26 SOUTH DRIVE
FELPHAM

I am writing to object to planning application FP/183/17/HH. The reason is because of its height. When I lived in Elmer I talked with an officer in your office about a building in the garden next door and was informed the height limit was 2 metres. There is no way the building erected can be called a garden shed.

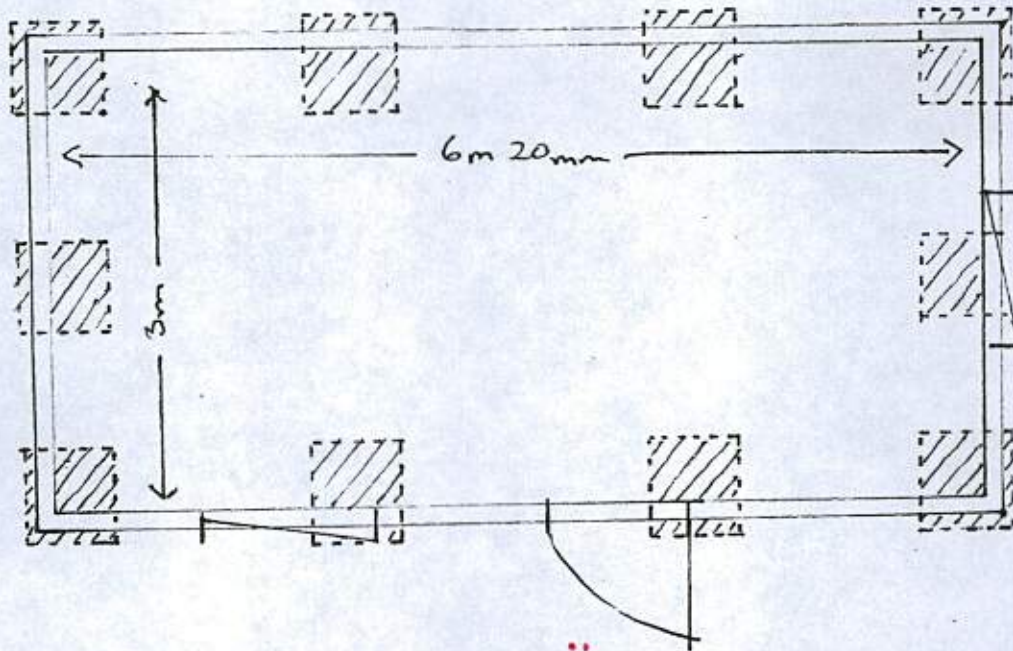
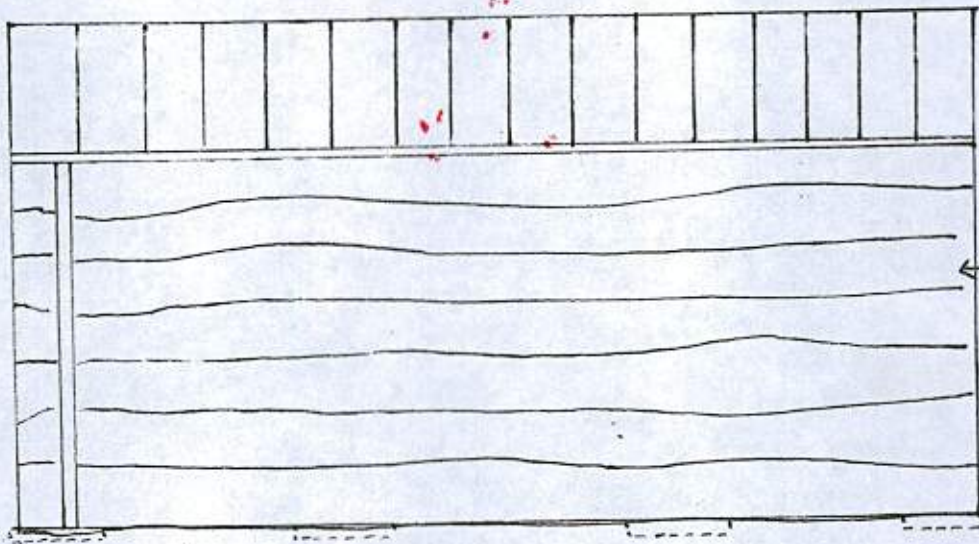
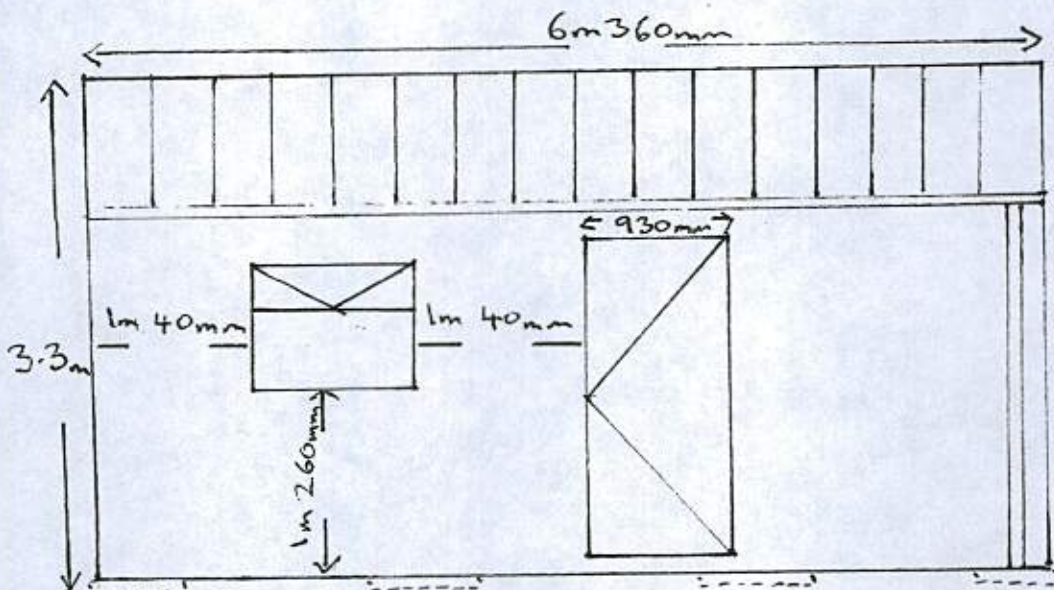
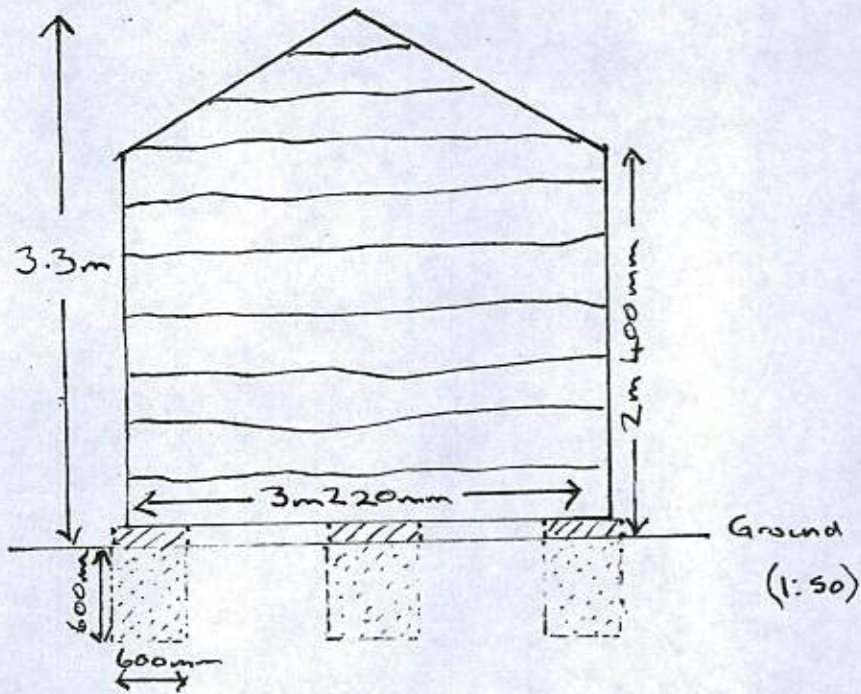
I have to admit I have been ematically upset by this building with its high windows overlooking my new home just weeks after moving into Felpham. I was widowed after 50 years and downsized. I carefully chose my new home to have the rear living area not overlooked. This did not last long.
